Recommendation Report for Planning Permission for Works or Extension to a Dwelling

REF NO: M/100/25/HH

LOCATION: 9 Central Drive  
Middleton-on-sea  
PO22 7TT

PROPOSAL: Single storey front extension, removal of chimney, and alterations to fenestration.

Drawing Name: Proposed Ground Floor Plan

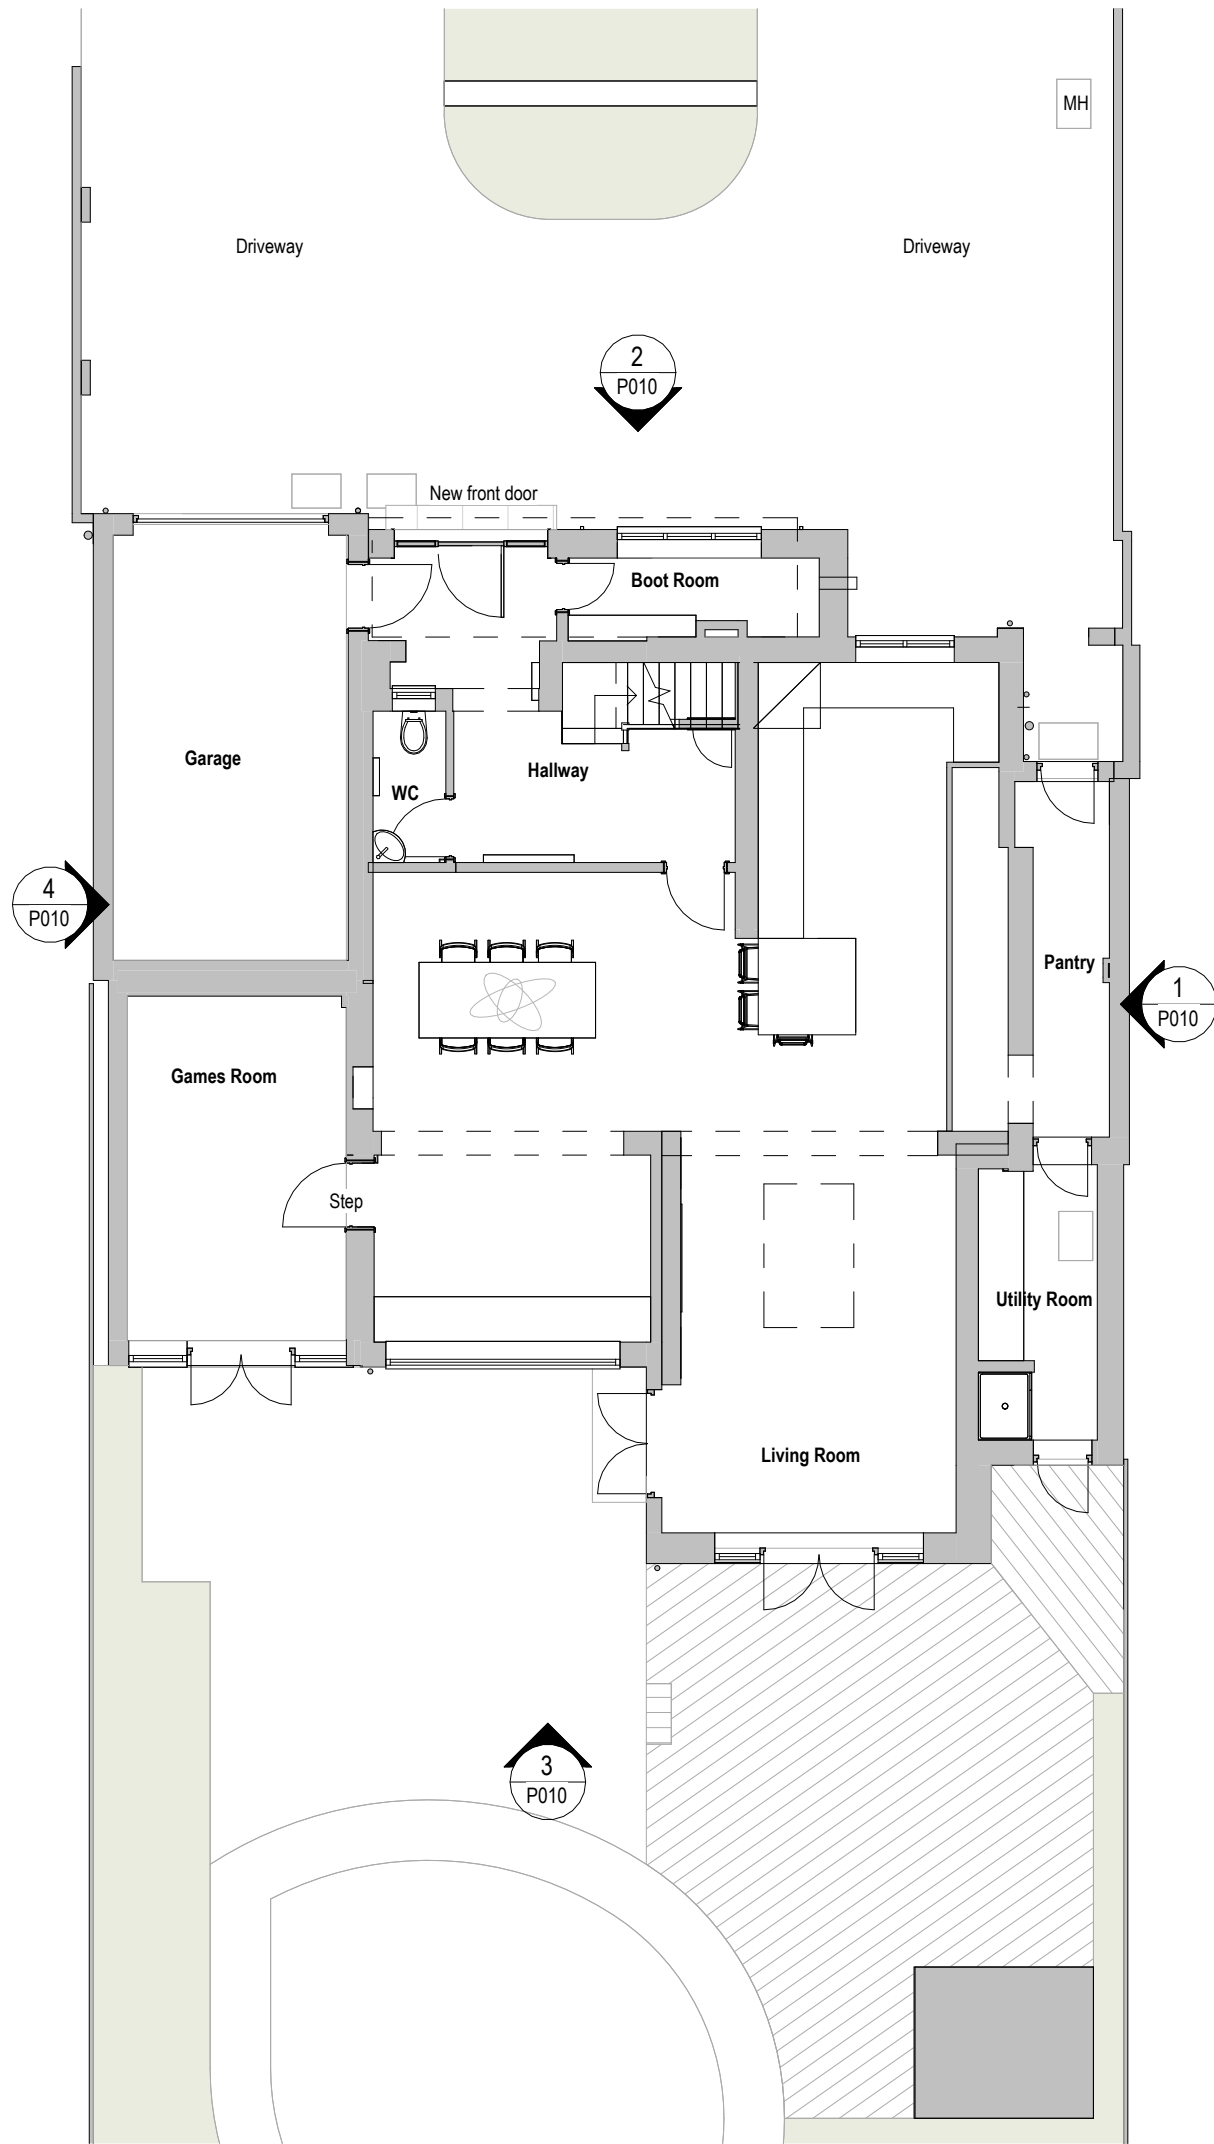
The proposed porch would replace an existing smaller porch, extending approximately 0.8m further towards the eastern flank of the host dwelling and would be built to approximately the same height (3.6m). The proposed porch would not encroach further to the north than the existing porch, remaining marginally set back from the garage to the west. The porch would have a pitched roof similar to the existing, sympathetic to the roof form of the host dwelling.

The current porch comprises an open canopy towards to western flank, accommodating the front door on the eastern elevation. The extension proposed would lose this open element, with the front door being relocated on the front elevation. Whilst this would create a more imposing frontage, the extension would remain subservient to the host dwelling and would not detract from the visual amenity or character of the area, therefore is in accordance with Arun Local Plan policies D DM1 and D DM4.

Proposed First Floor Plan

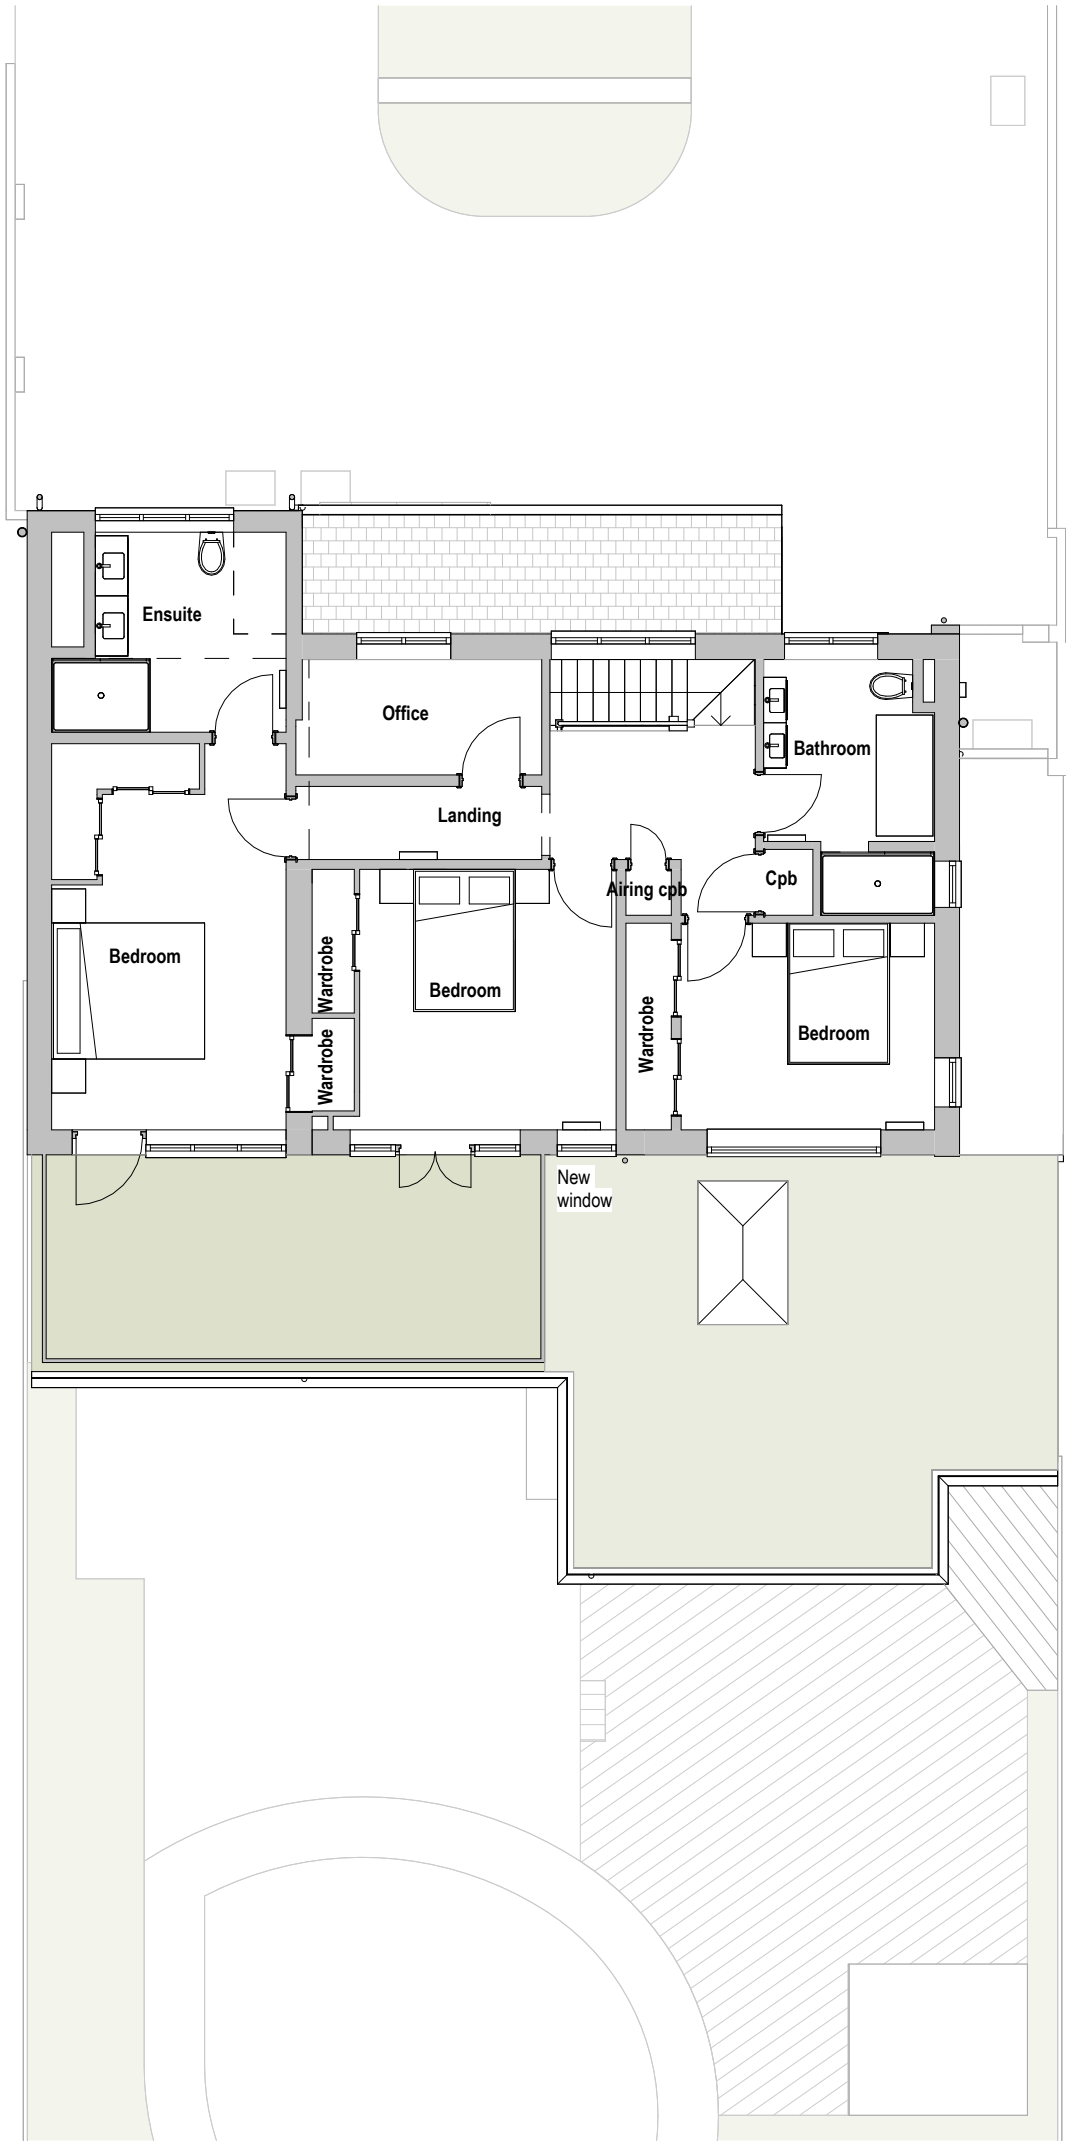
A new window is proposed on the south elevation at first floor level to accommodate an amended internal layout. The window is to be located centrally, similarly to the window proposed for removal, and would not have an impact in regard to design and visual amenity.

elevation would replace an existing window and be installed approximately 0.5m further west. The window may allow for oblique views into the rear gardens of 11 and 7 Central Drive, to the east and west but, given that 11 Central Drive is set back from the host dwelling and there is currently a window installed, the proposal would not have unacceptable overlooking impacts.

Proposed Elevations

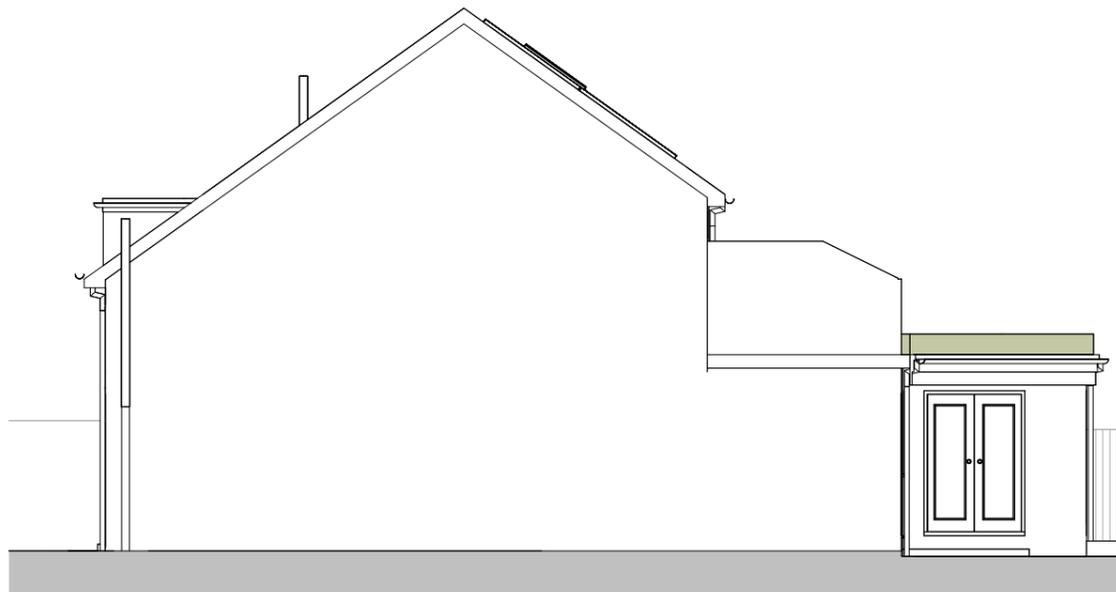
Currently, the host dwelling has a chimney, which is proposed for removal as part of the application. Central Drive has a varied street scene with both recently developed, modernised dwellings without chimneys as well as older, more traditional designs with their original chimney. The removal of the dwelling would not result in harm to the visual amenity of the host dwelling or character of the area.

It is proposed to introduce light-coloured window frames to the fenestration at first floor and ground floor level on the north elevation. The proposed porch would have a new window to serve the ground floor accommodation and, as mentioned previously, would include a new front door with obscurely glazed, full length windows either side. Central Drive has a varied street scene and material palette; the proposal would not harm the visual amenity of the local area and as such, is in accordance with Arun Local Plan policies D DM1 and D DM4.

Proposed Block Plan

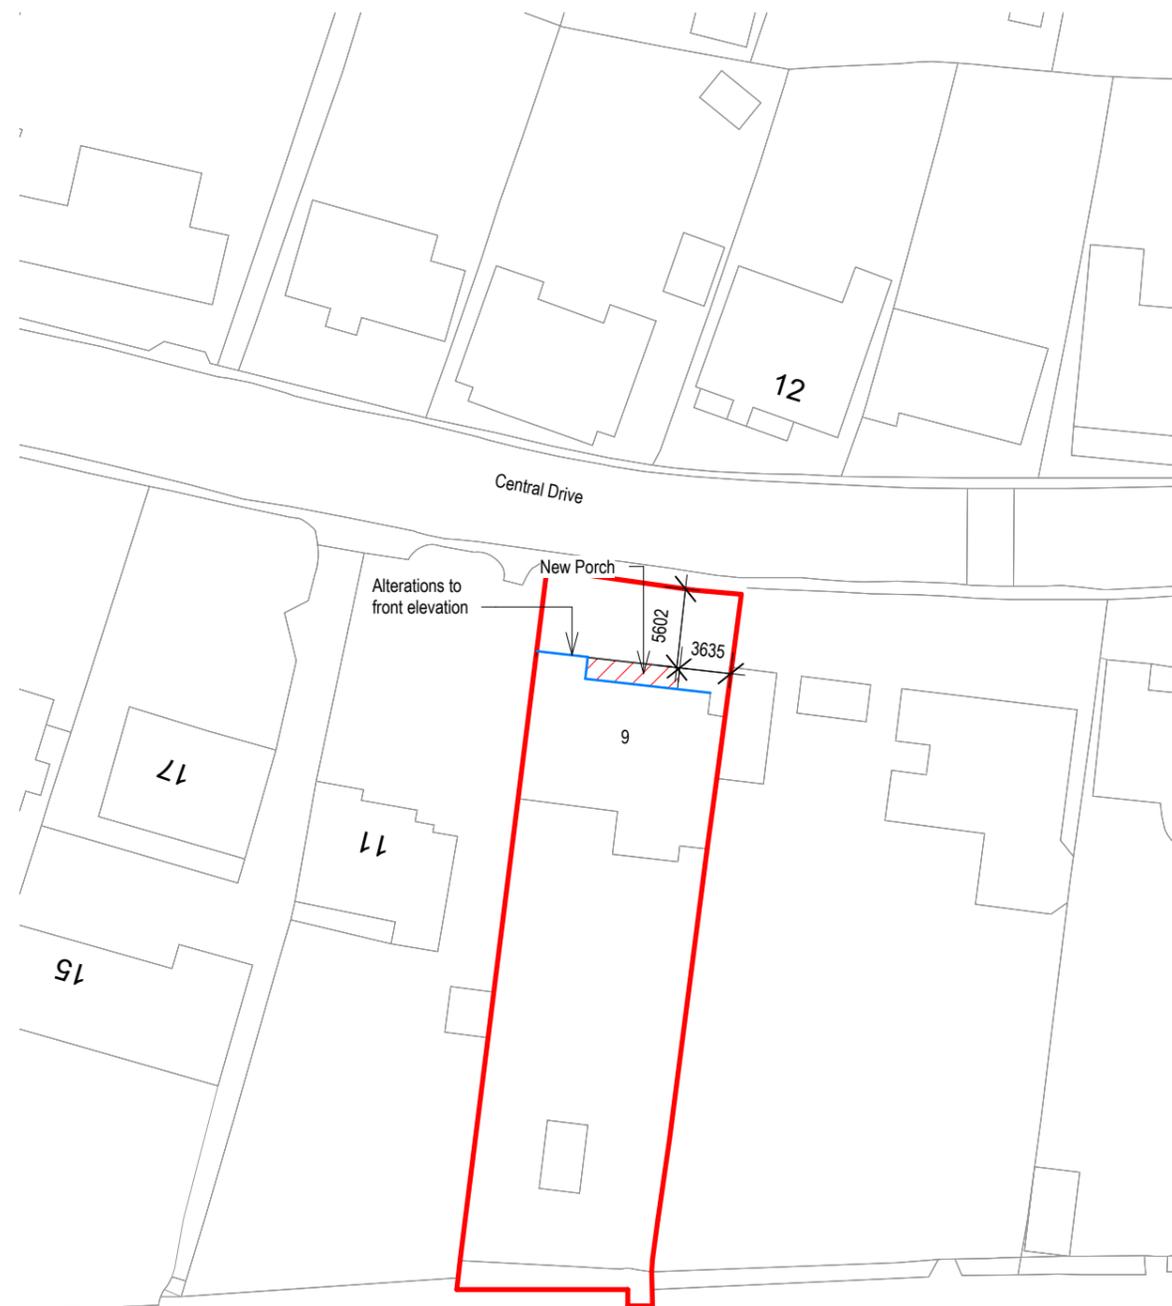
In this instance, the extension would be constructed over an area of existing hard standing and would not result in an increase of impermeable or hard surfaces within the application site.
